# CITY OF ALBUQUERQUE

November 30, 2015

**RE: Montoya Street Townhomes (File: H12D019A)**  
**Tracts A1 and A2 Lands of David Maciel**  
**Montoya St NW between Floral Rd and I-40**  
**Grading Plan and Drainage Report**  
**Engineer's Stamp Date – 10/15/15**

ENGINEER'S SEAL	MONTOKA STREET TOWNHOMES	DRAWN BY WCMJ
	DAVID SOULE	GRADING AND DRAINAGE PLAN	DATE 10-15-15
	10/15/15		21523-LAYOUT-8-05-15
DAVID SOULE P.E. #14522		1806 CENTRAL AVENUE SE SUITE 201 ALBUQUERQUE, NM 87106 (505) 872-0999	SHEET # JOB # 21523

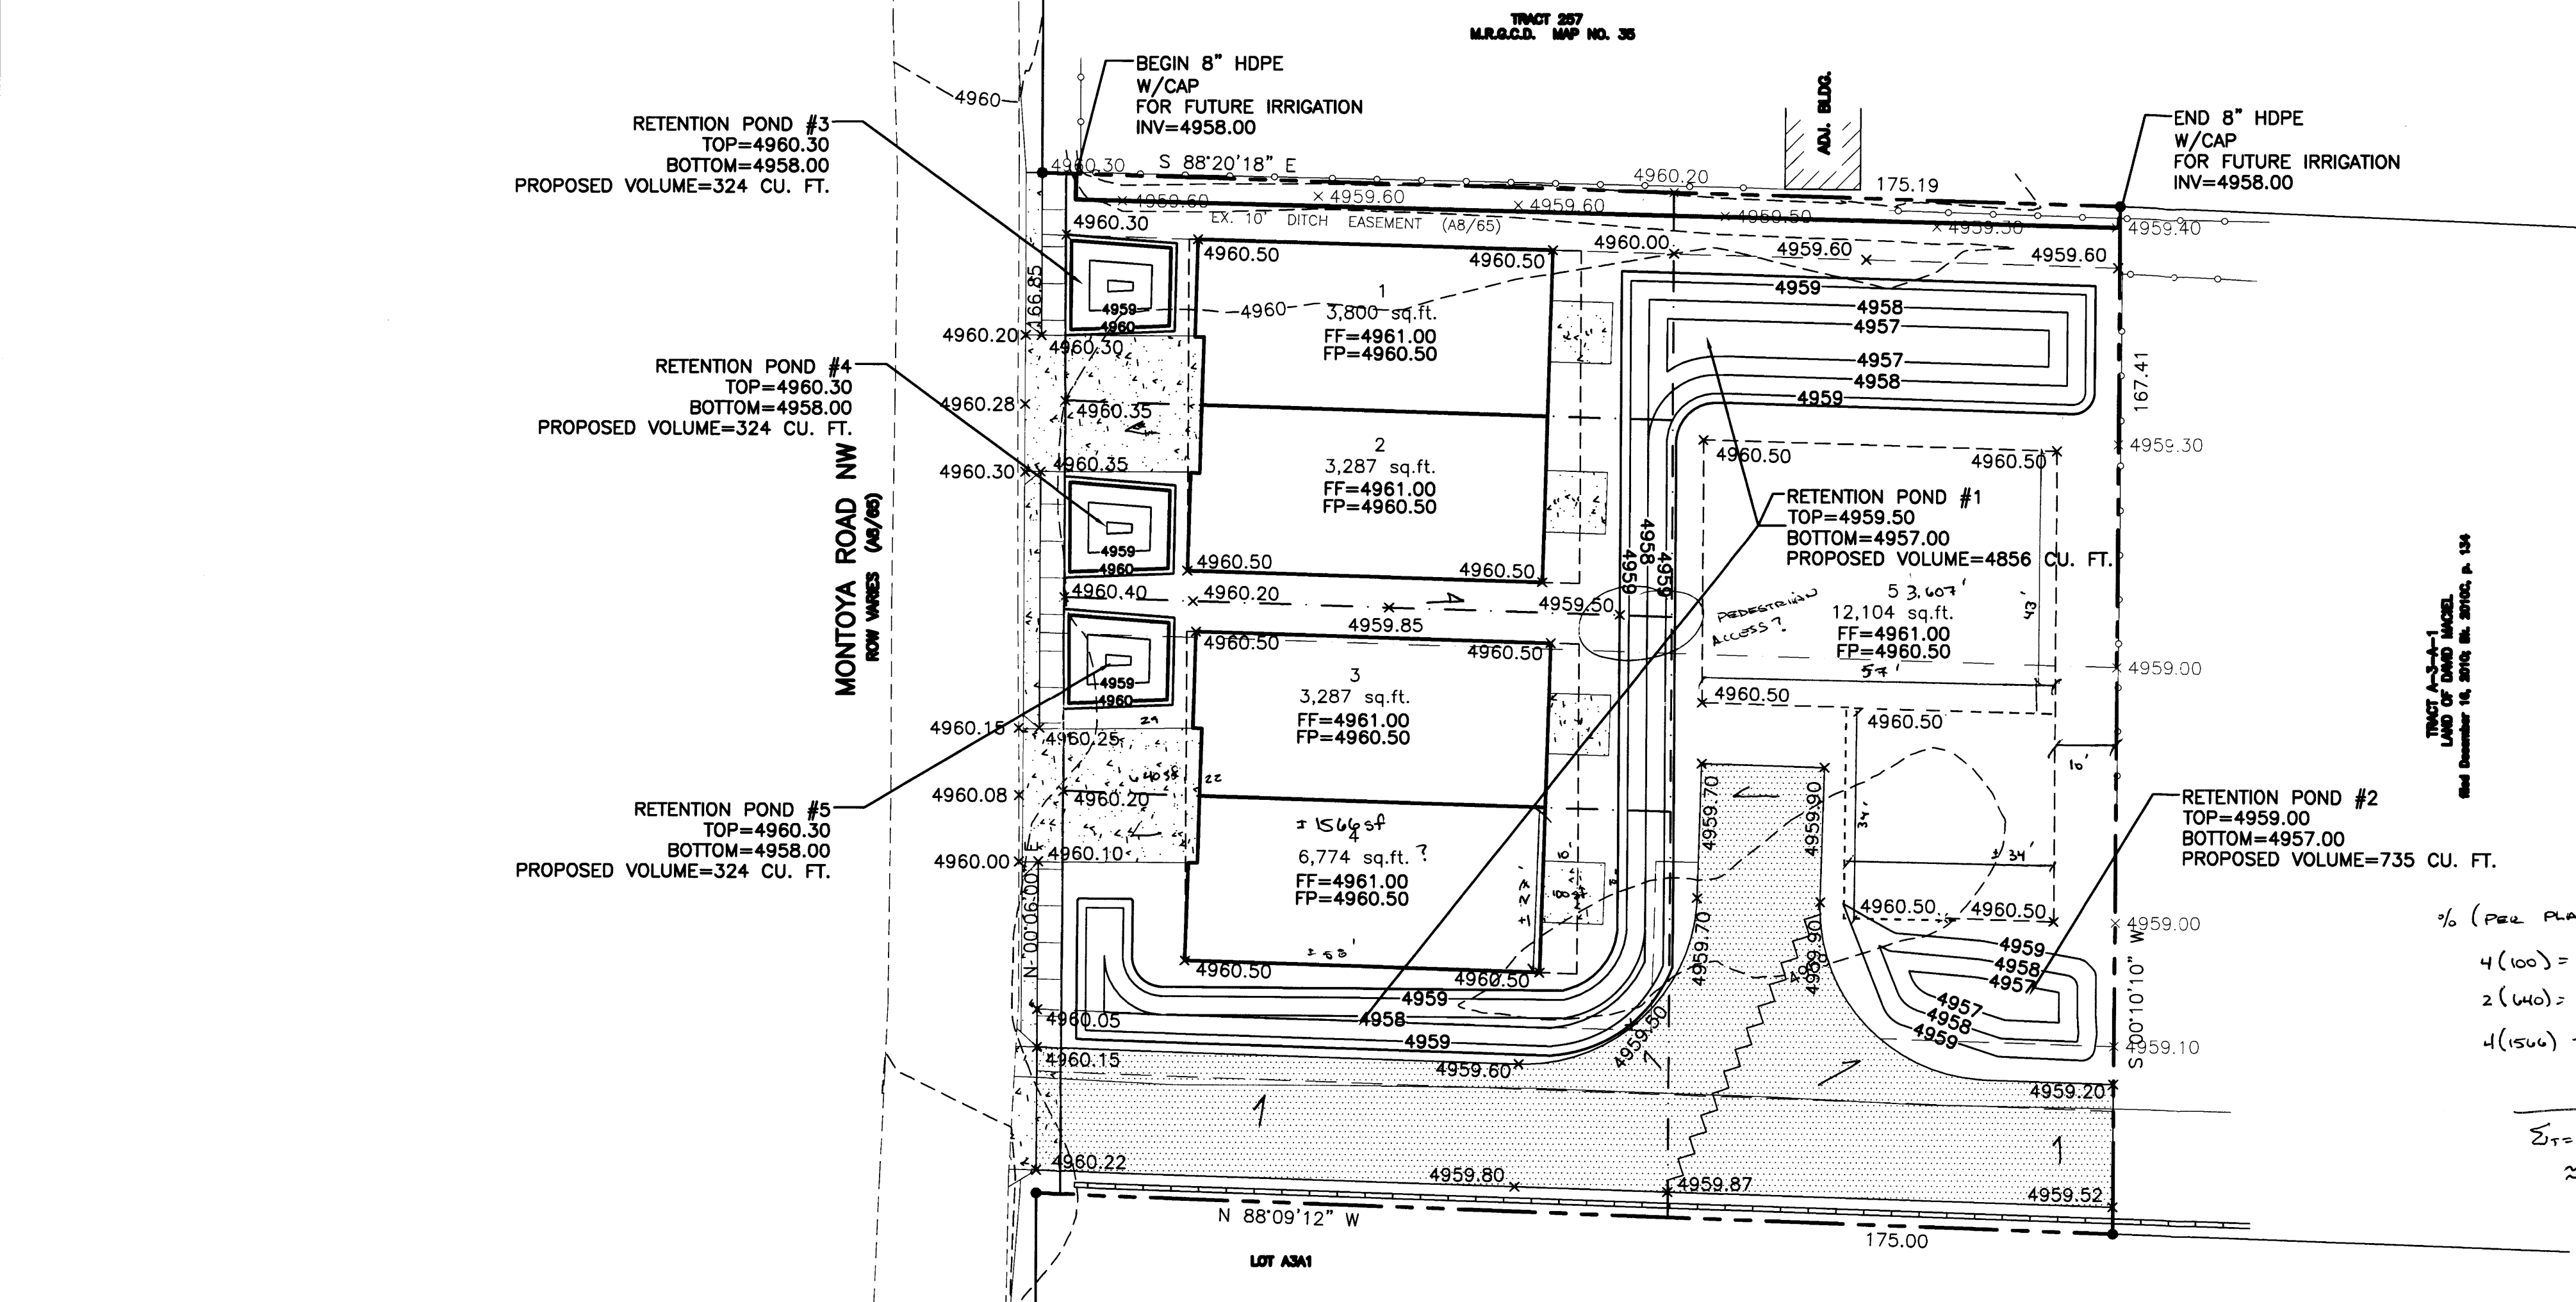
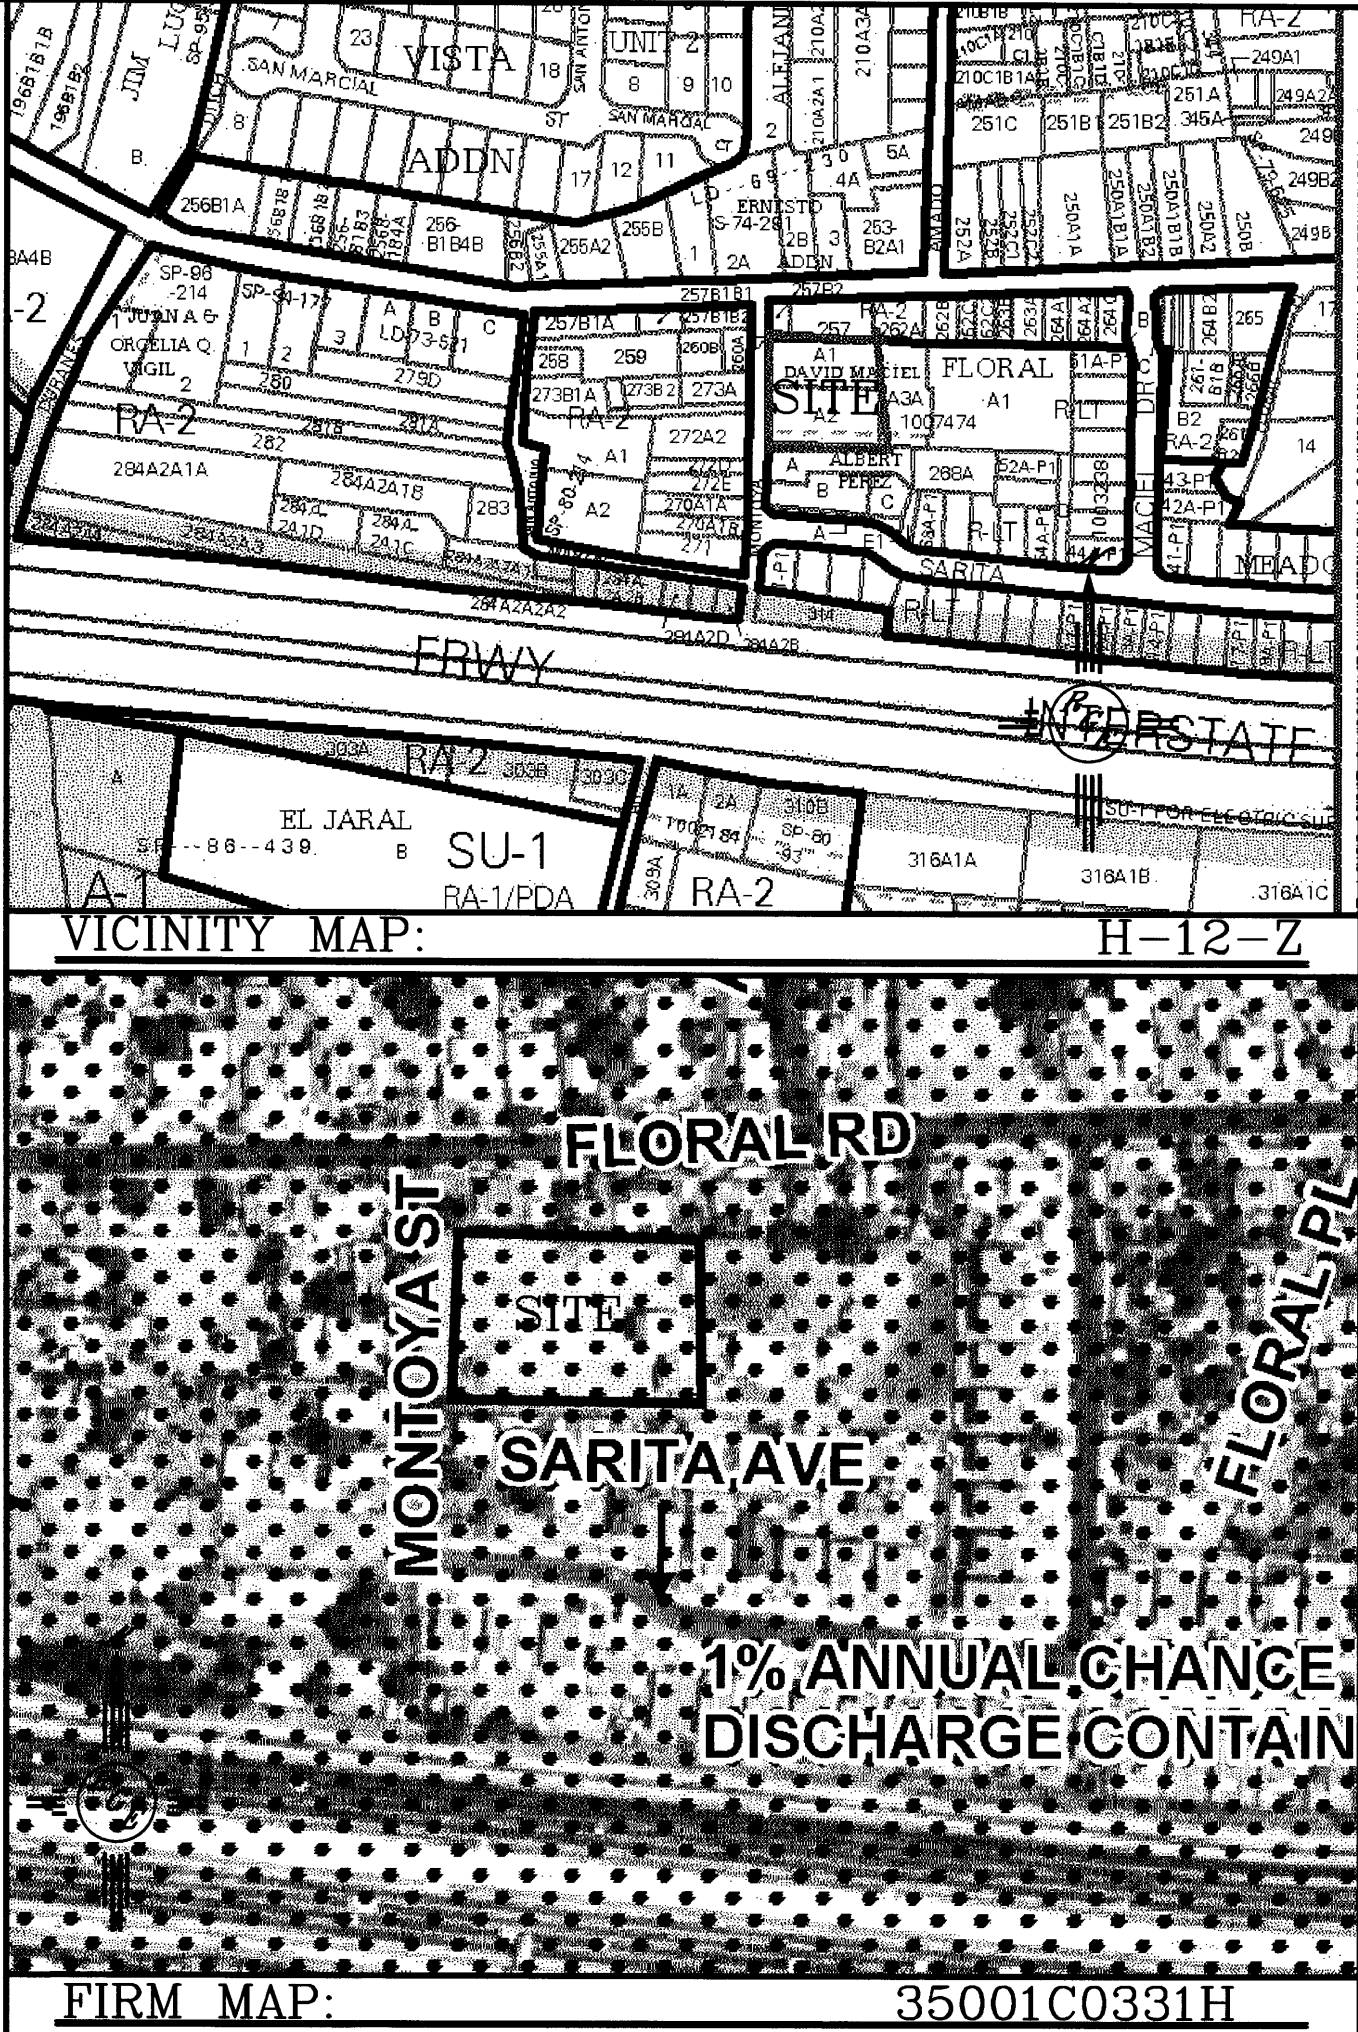
- Provide drainage flow areas to better identify overall site drainage patterns.
- Provide roof flow direction and outfall locations.
- Clearly identify and define property lines.

- Clearly identify the location and limits of the 10 ft Ditch Easement located on the north property line.
- The Drainage Report indicates flows from a storm event exceeding the 100-yr, 6 hr storm event will discharge to Montoya Street. Per the spot elevations identified on the Grading Plan, it appears flows will be directed east away from Montoya Street. Show on the Grading Plan how this will be achieved.

- The Drainage Report states the platting action will allow for cross lot drainage easement on all parcels yet the Drainage Report identifies flows to be retained onsite or discharged onto Montoya Street during a larger design storm. Provide offsite flow information and how offsite flows will be managed onsite.

- A scale check on the area for townhomes 1-5 appears as though the area provided is incorrect. Re-check the areas to ensure the information is correct.
